A1 in Northumberland: Morpeth to Ellingham

Scheme Number: TR010059

7.13 Applicant's Response to Deadline 2 Submissions

Applicant's Response to Deadline 2 Submissions

Revision: P02

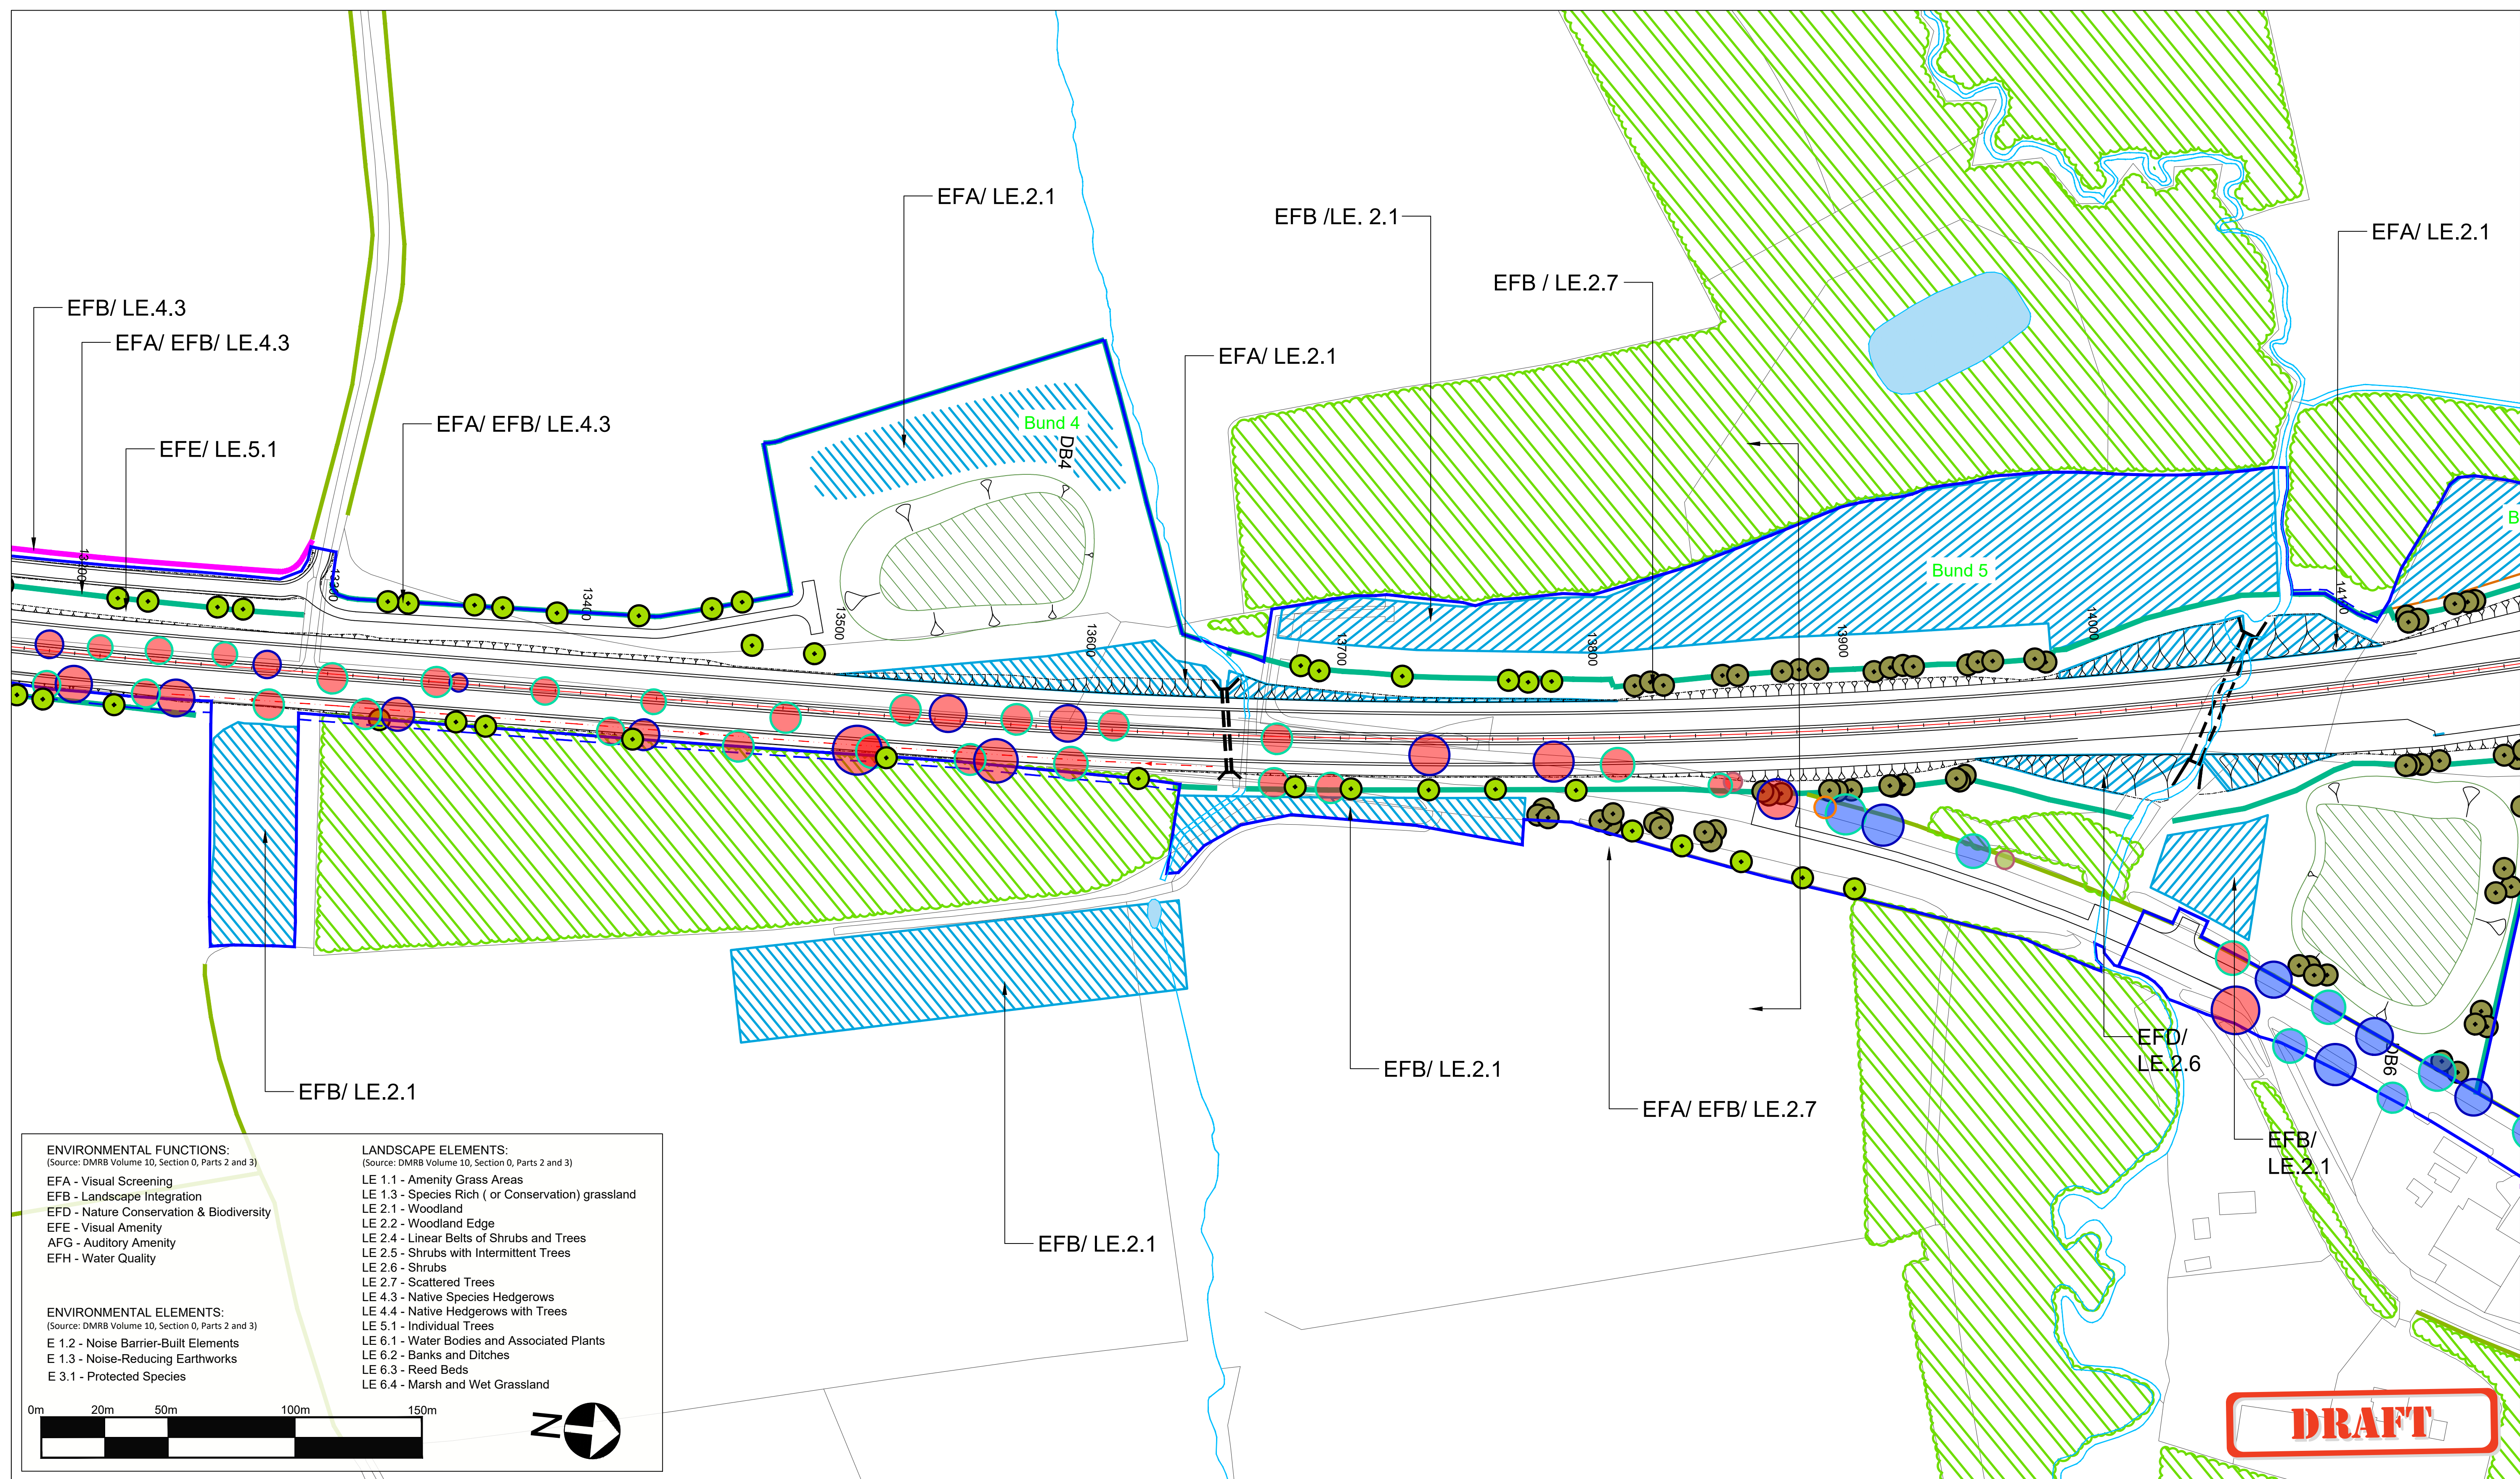
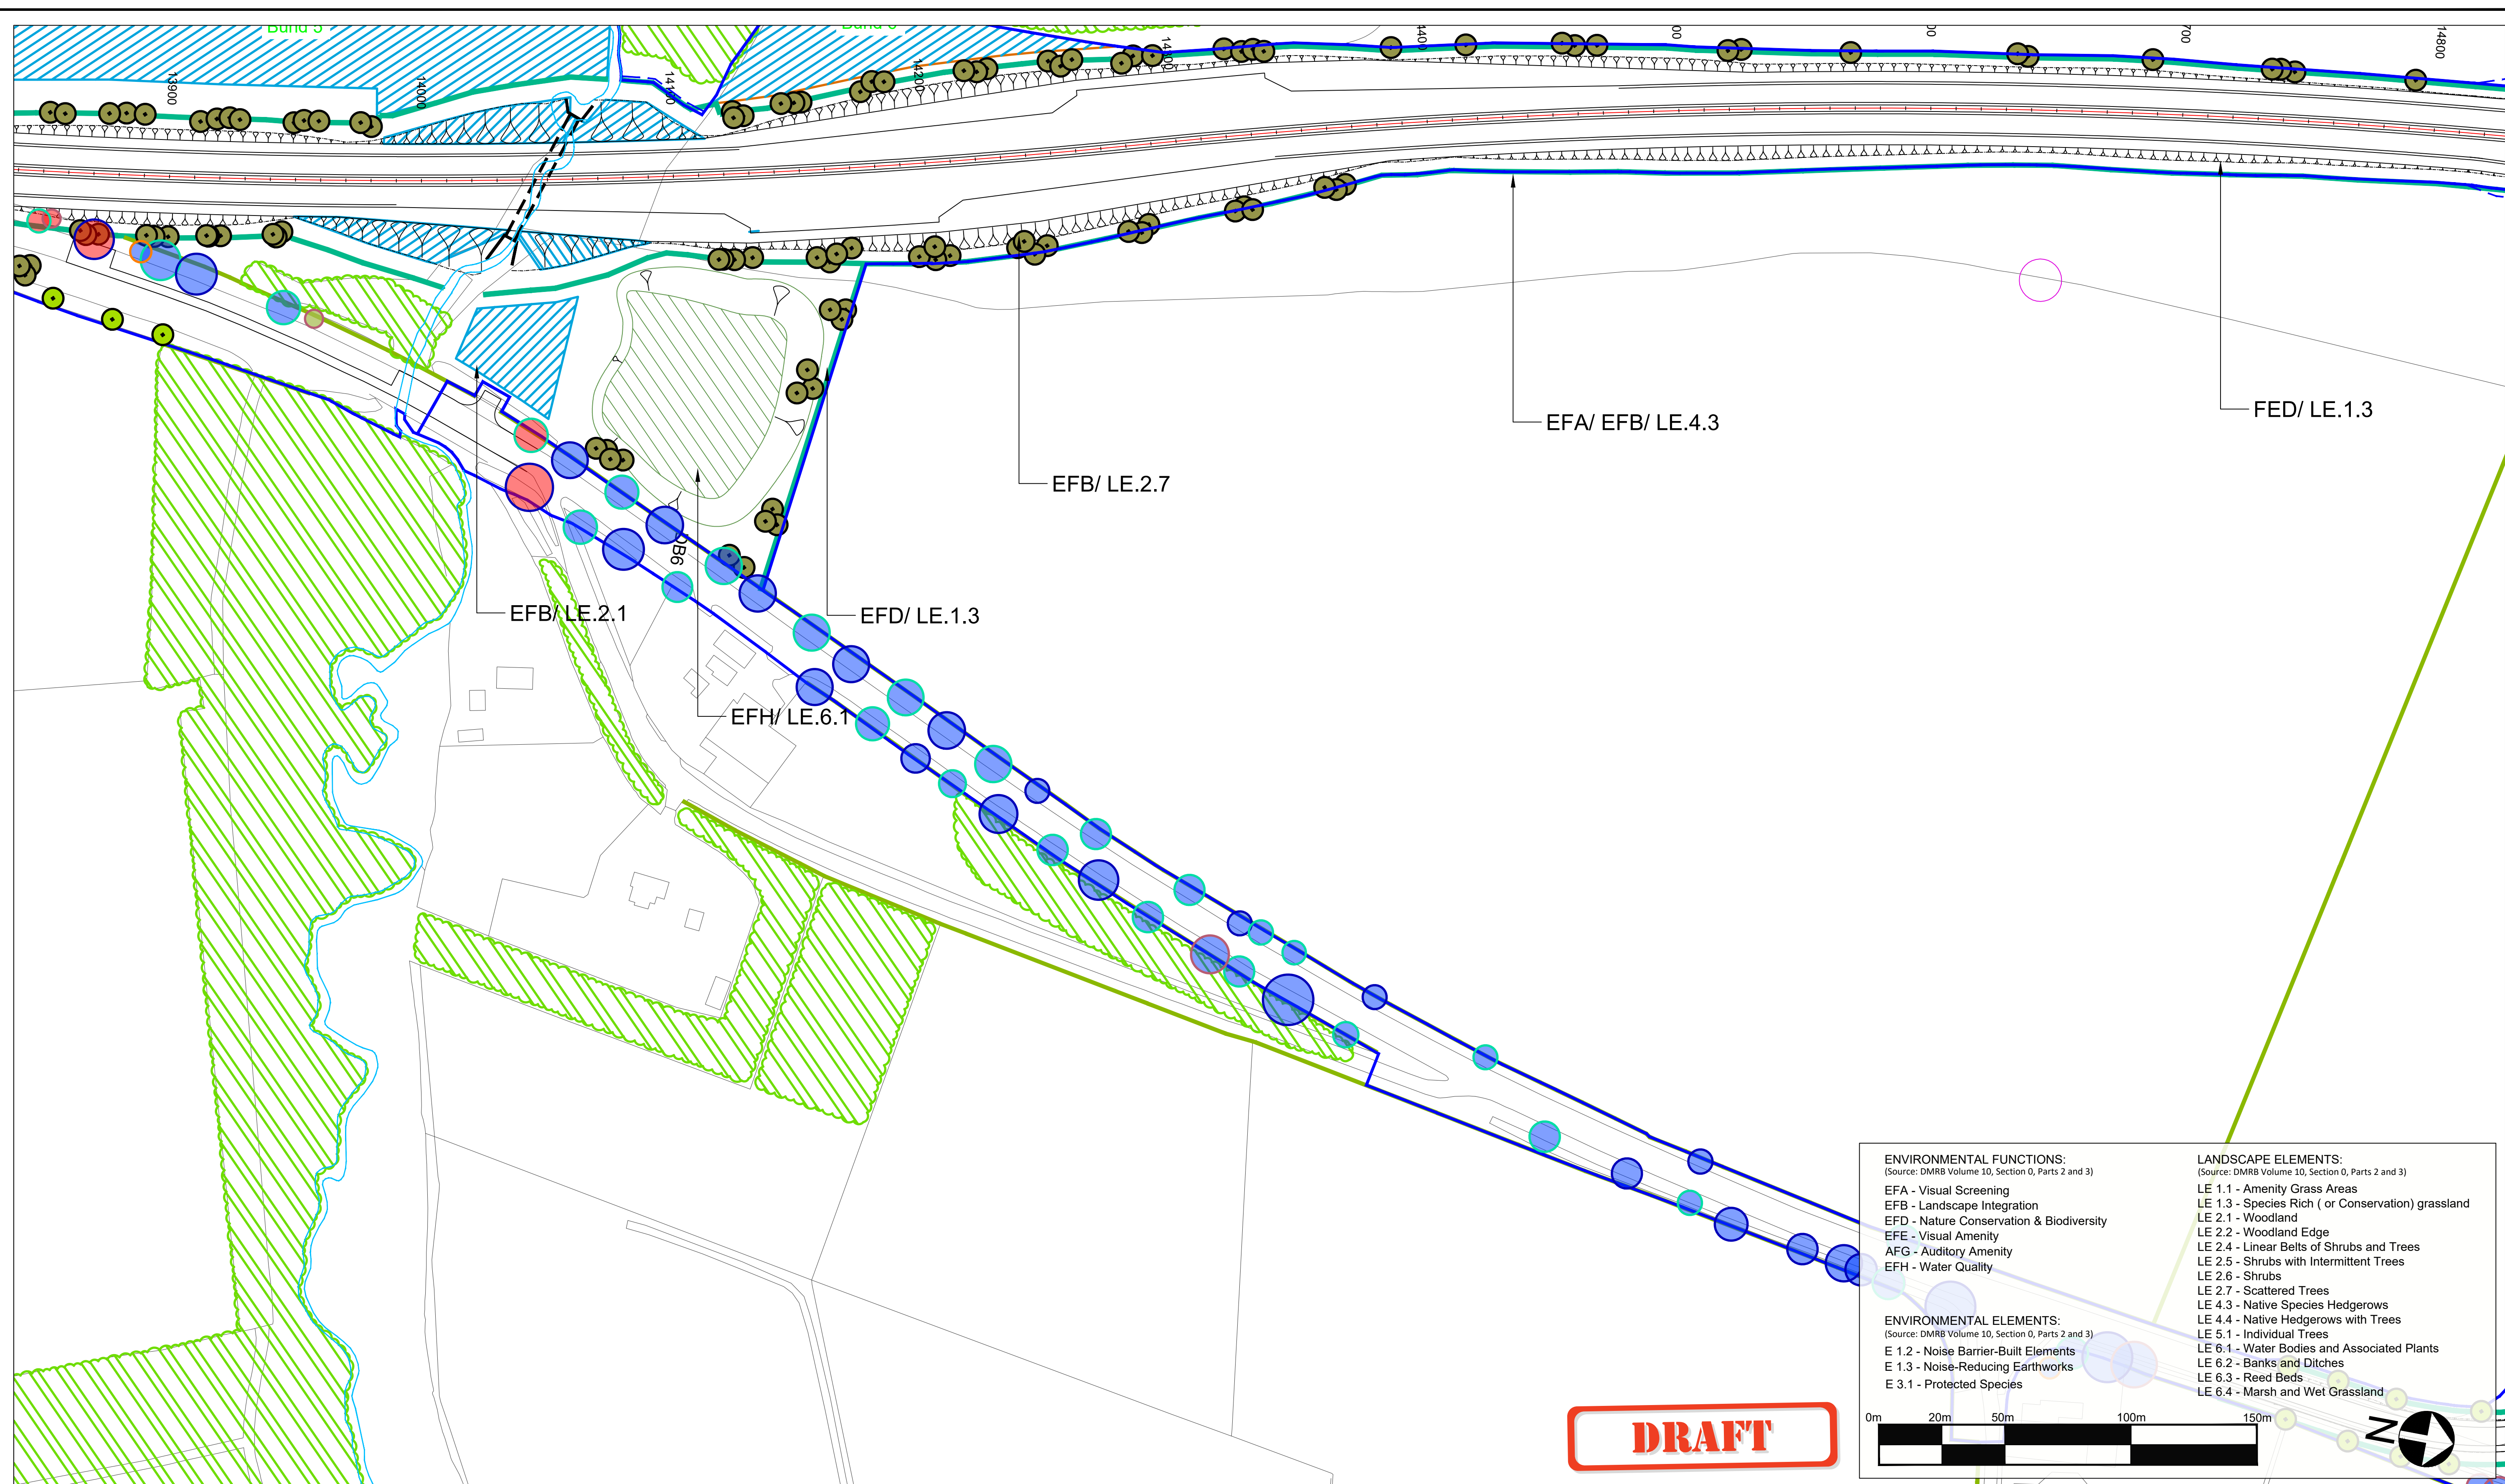
<p>Appendix LV.2 REP1-044</p>	<p>As previously reviewed and agreed.</p>	<p>1. It is noted that NCC are in agreement with Appendix LV.2 [REP1-044] which sets out the proposed approach to replacing trees at Coronation Avenue.</p>
